Re: Roberts Road Quarry MOD 2 (DA 267-11-99)

**Proposed Modification Request to an Existing Extractive Industry
Hodgson Quarry Products – Lots 1 and 2 DP 228308 and Lot 2 DP 312327, Roberts
Road, Maroota**

**Roberts Road Quarry Modification 2 (DA 267-11-99 Mod 2)
Response to exhibition of Environmental Impact Statement**

Roberts Road Quarry Modification 2 (DA 267-11-99 Mod 2) Response to exhibition of EIS Detailed comments - DPI Water

DETAIL 04: PERMANENT BUND WALL SECTION

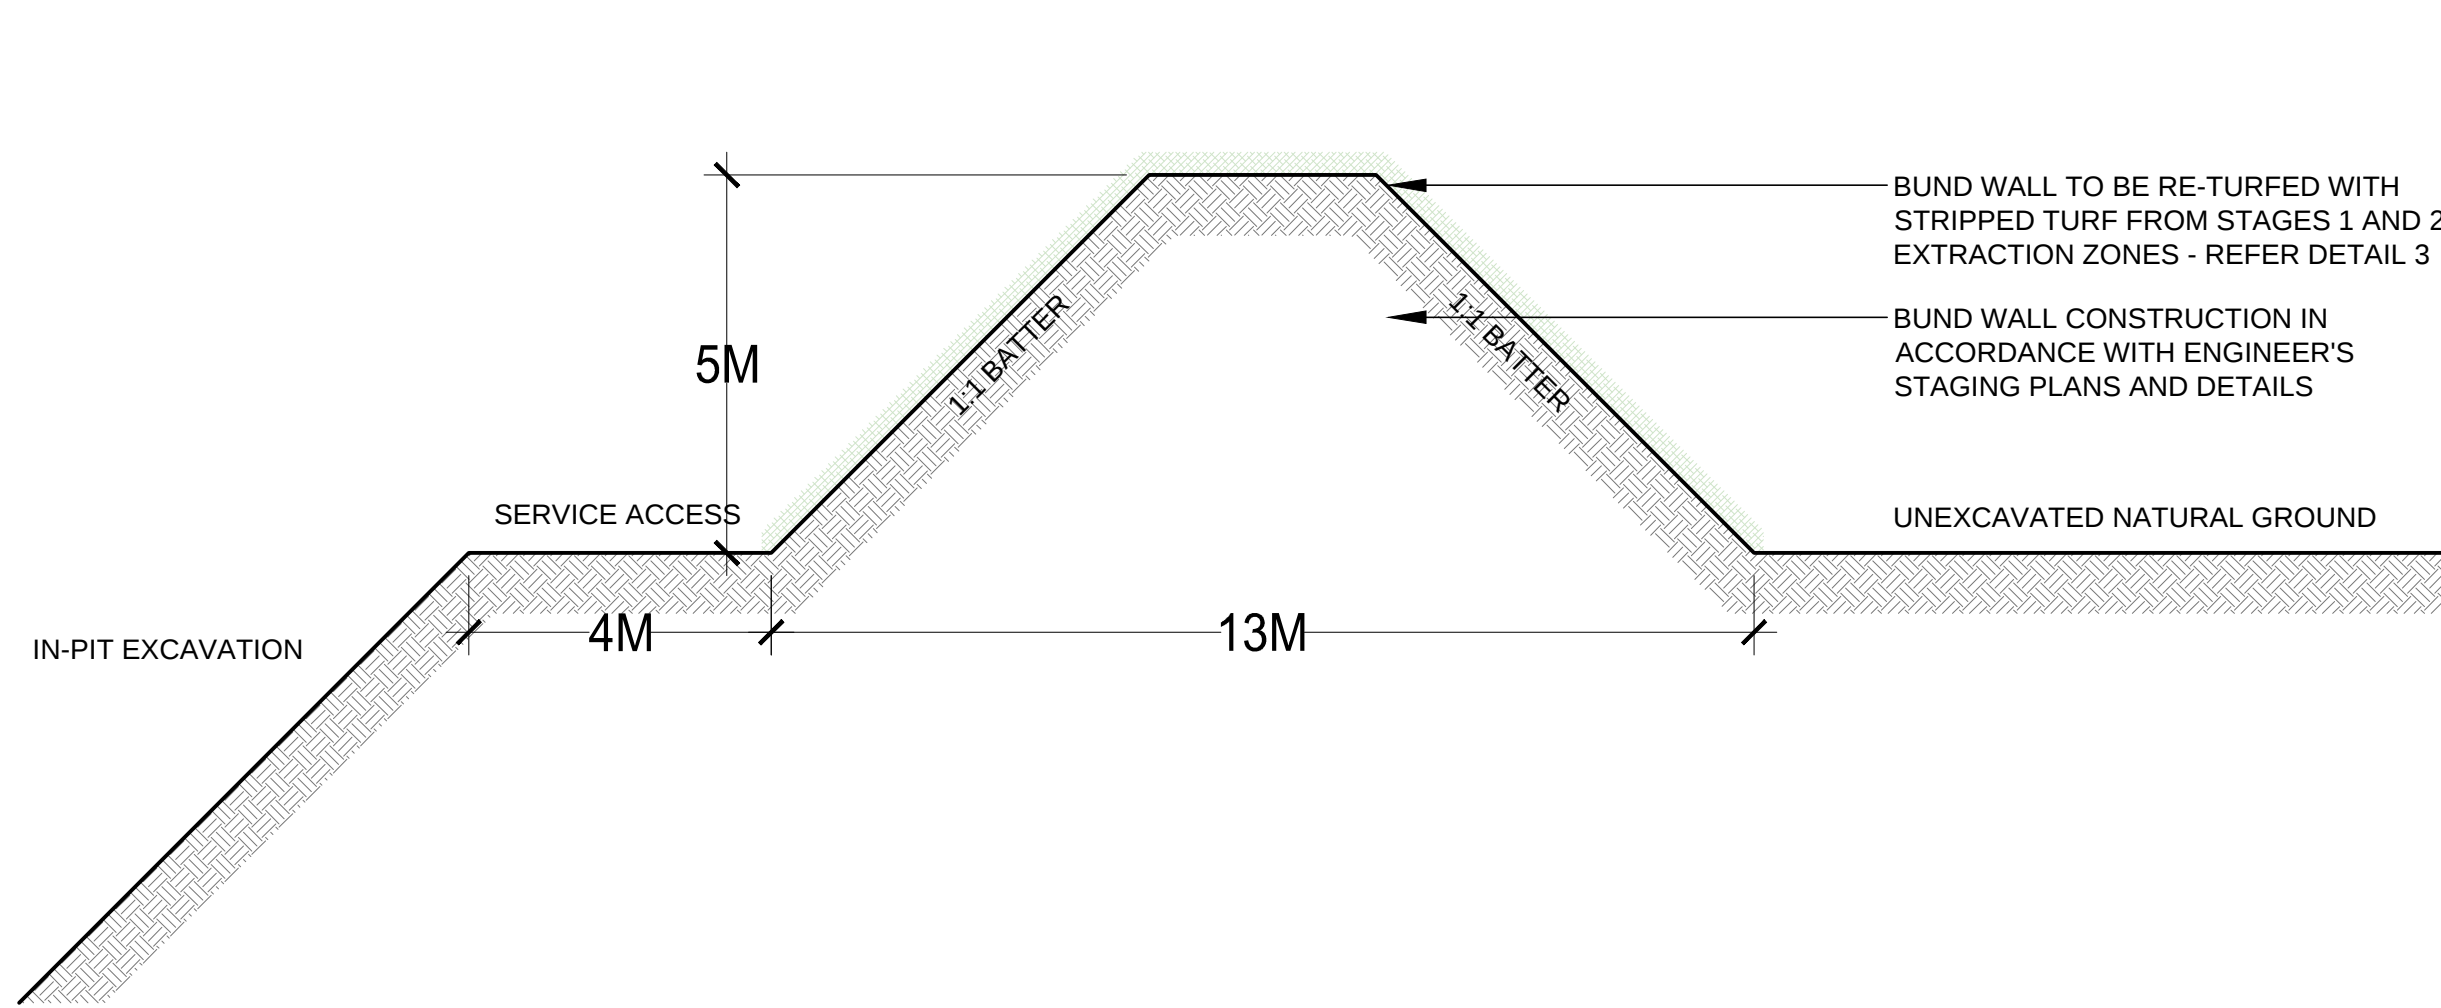
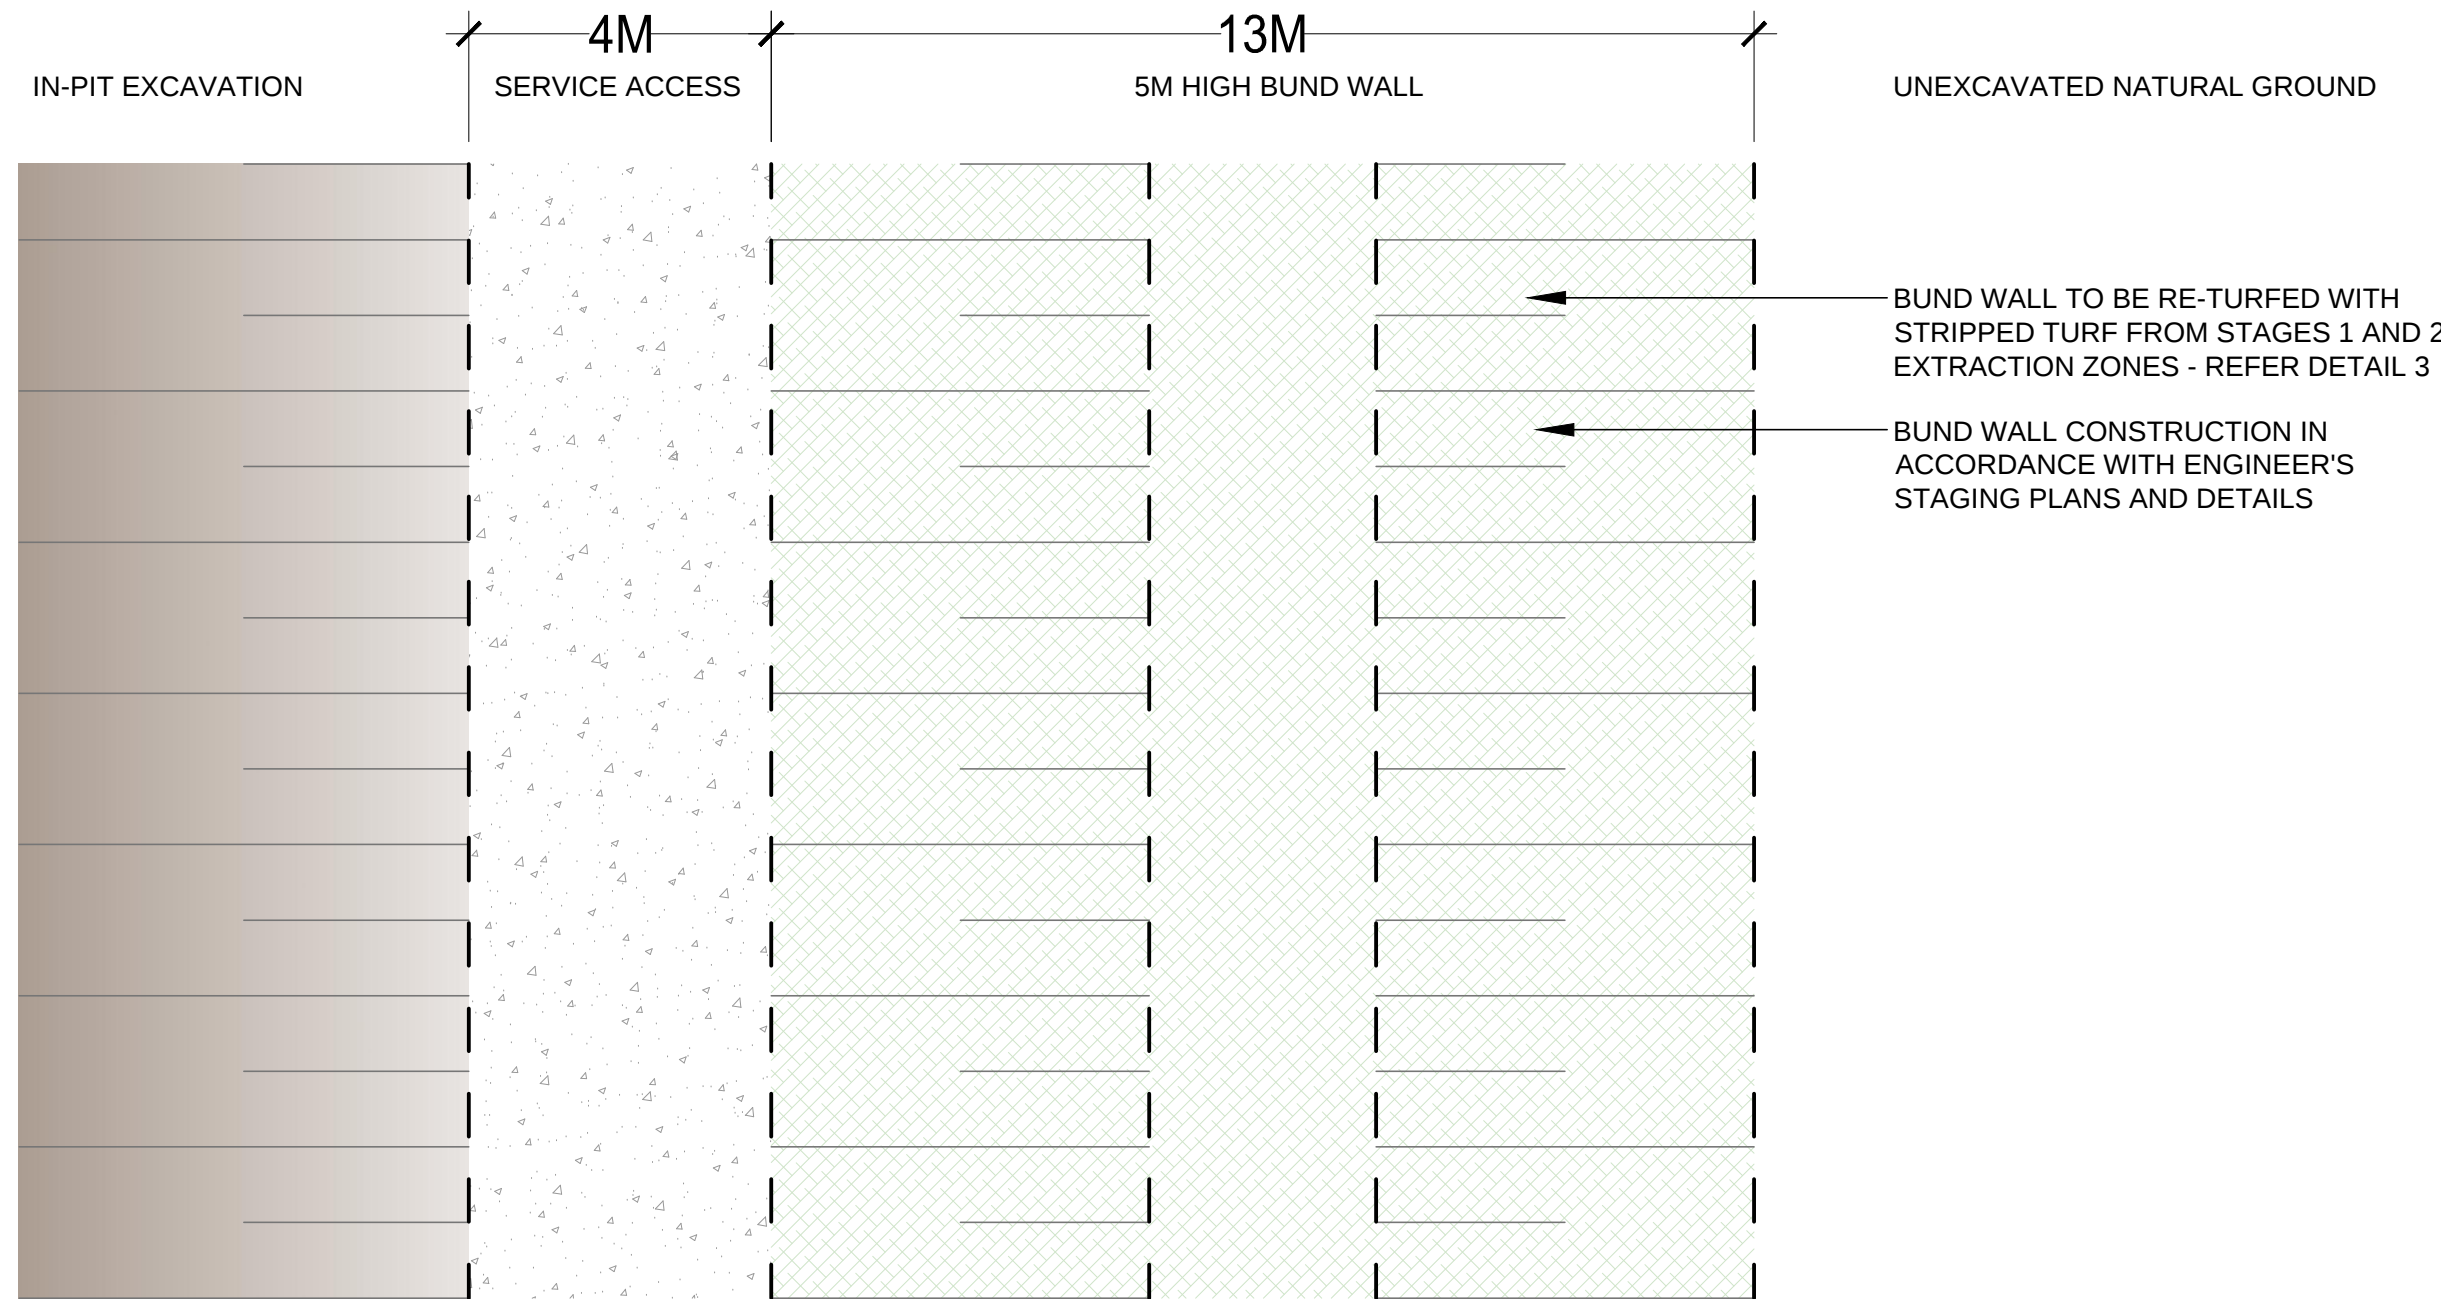
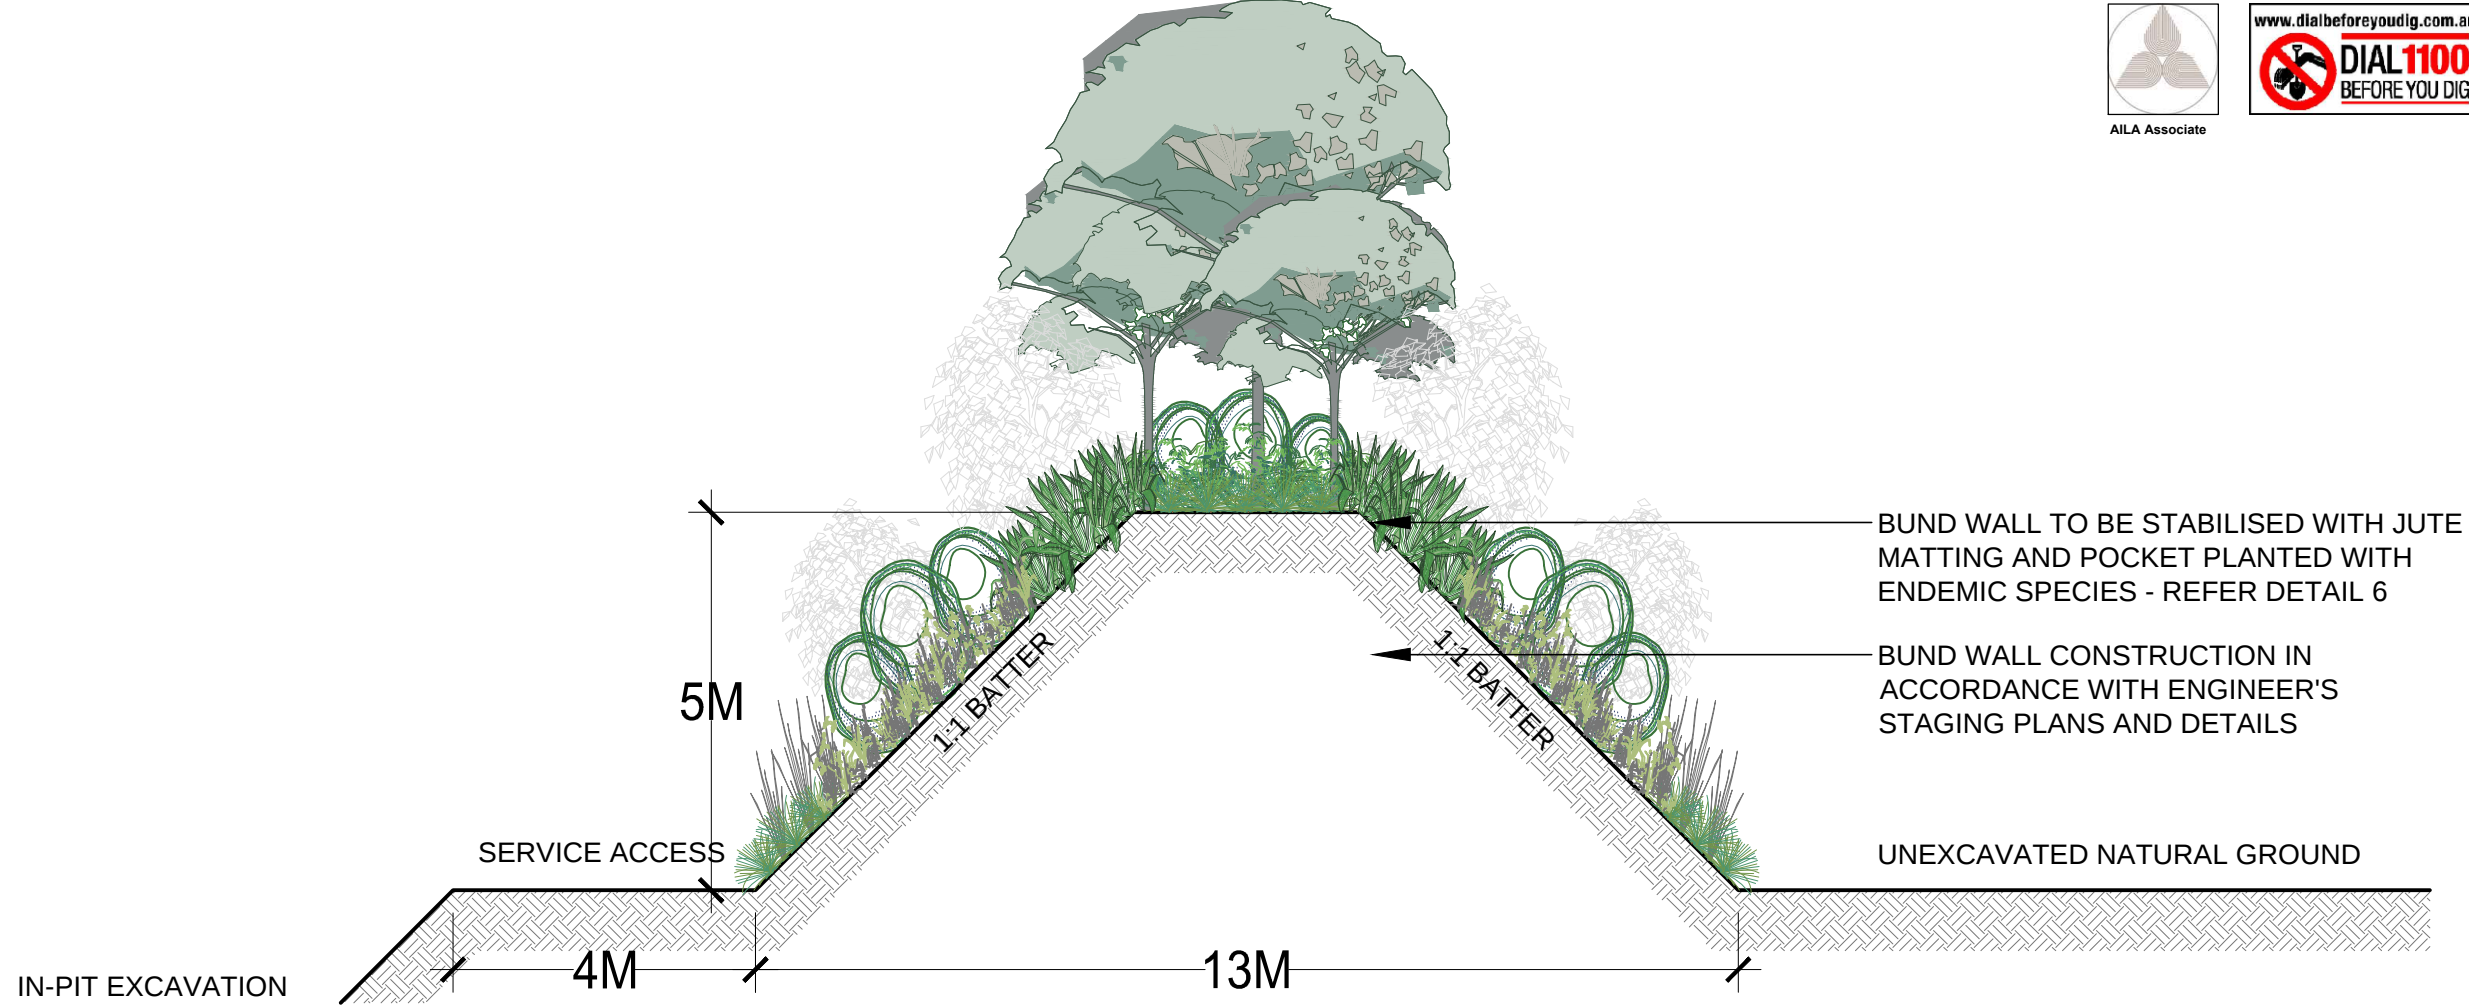
1. The modification application does not adequately consider potential impacts to adjoining property owner's given the additional period requested for extraction. Of particular concern is the visual impact of the proposal. The Statement on page 3-69 refers to the original EIS and refers to '*extensive screen planting, supplemented with earth bunding...*'

In this regard some bund walls have been constructed with some landscape works. The bund walls provide a reasonable screen however the landscape works undertaken are not consistent around the boundary and does not provide an adequate screen.

Additional landscape work is required to reduce visual impact.
